City of Albuquerque Stormwater Construction Site Inspection Report

ESC File No.	G11E069	Project Name:	Coors Pavilion
NPDES Id. No.	NMR10052A & 52U	Location:	St Josephs St. NW
11/8/2022	Owner	Contractor	NMR10052U
Operator	Red Shamrock 4, LLC	Scarsguard Construction, LLC.	
Contact name & title	Josh Skarsguard	Trish Kvern	
e-mail	Josh@scarsguardfirm.com	trish@retailsouthwest.com	
Contact Phone #	262-2323	998-9093	
COA Inspector	Doug Hughes	Start/End Time:	11:00 -12:00 AM
Construction Phase:	Staging		
Type of Inspection:	Regular	Storm Event	Past Storm Event >0.25"
		311/Complaint	Follow Up
Weather at time of inspection?	Cloudy	Temperature: ~	55
Estimated date of last storm 0.25" or greater	10/16/2022

AMENDMENT FOR MASTER DRAINAGE PLAN

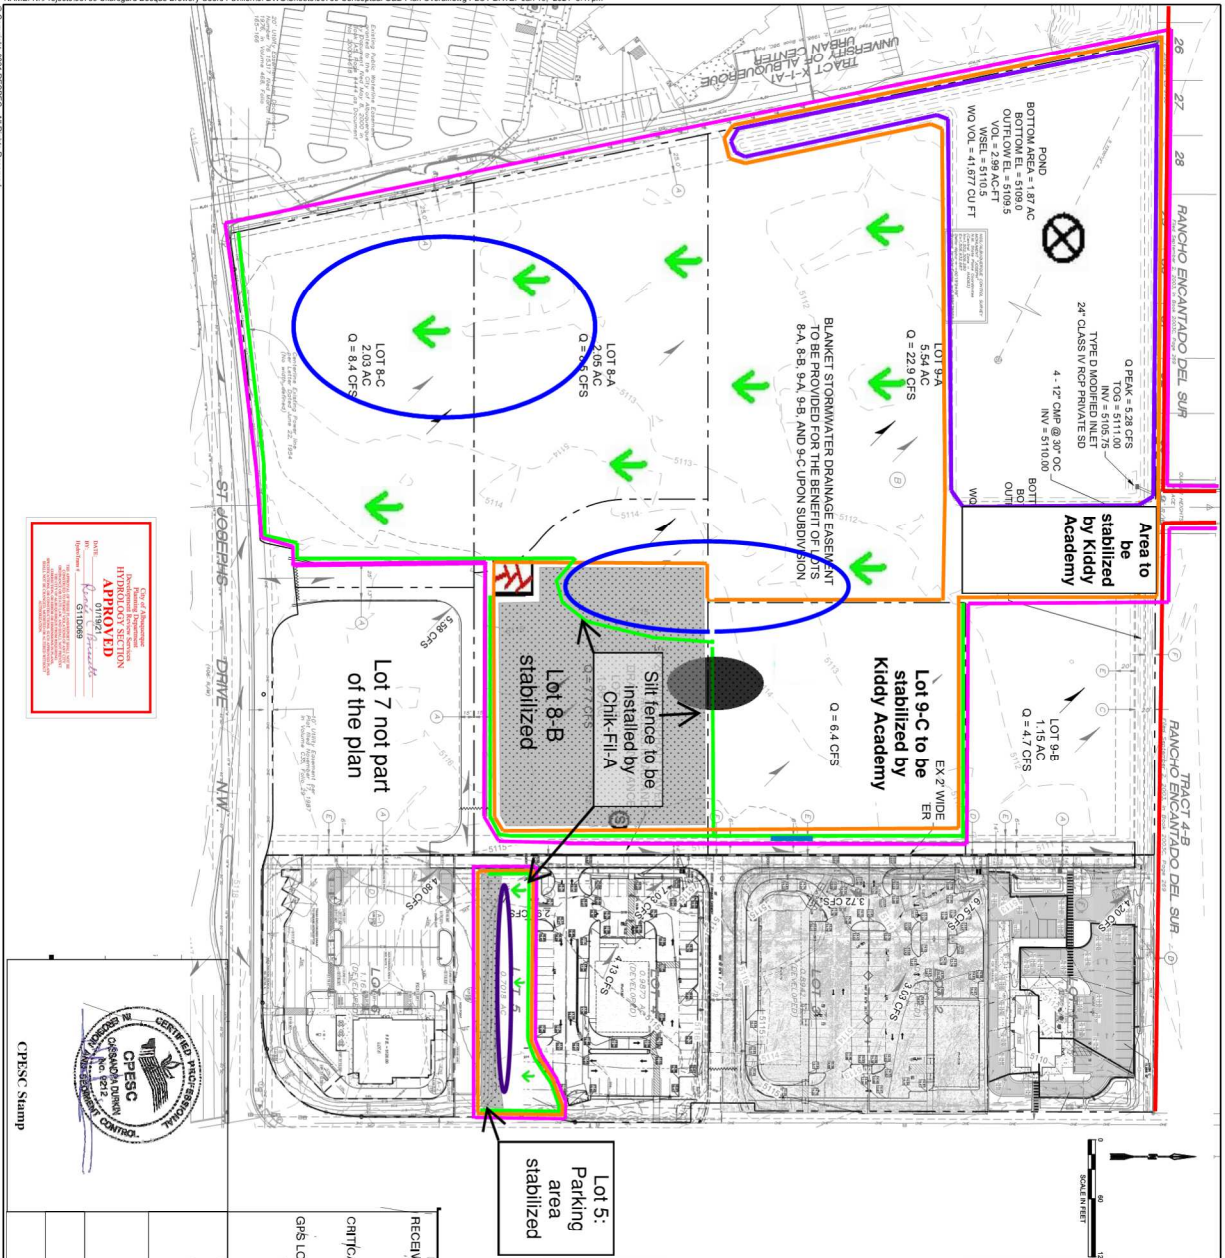
Item Number	Deficiency/ Corrective Action		
1	Silt Fence missing on Lots 5 and 8-B and though both have some gravel on them there still remains large bare spots so Final Stabilization Criteria isn't satisfied. Silt Fence Corrective Action required within 7 days.		
2	The SWPPP map doesn't reflect current site conditions because the SF is missing but not noted on the map and not addressed in a corrective action report. The Corrective action log and reports were missing from the SWPPP.		
3	Sediment was in the street south and east of Lot 8-B and must be removed immediately.		
2.1	Discharge off site? (Y/N)	no	
4	Self Inspection Reports	Latest report Date:	10/28/2022
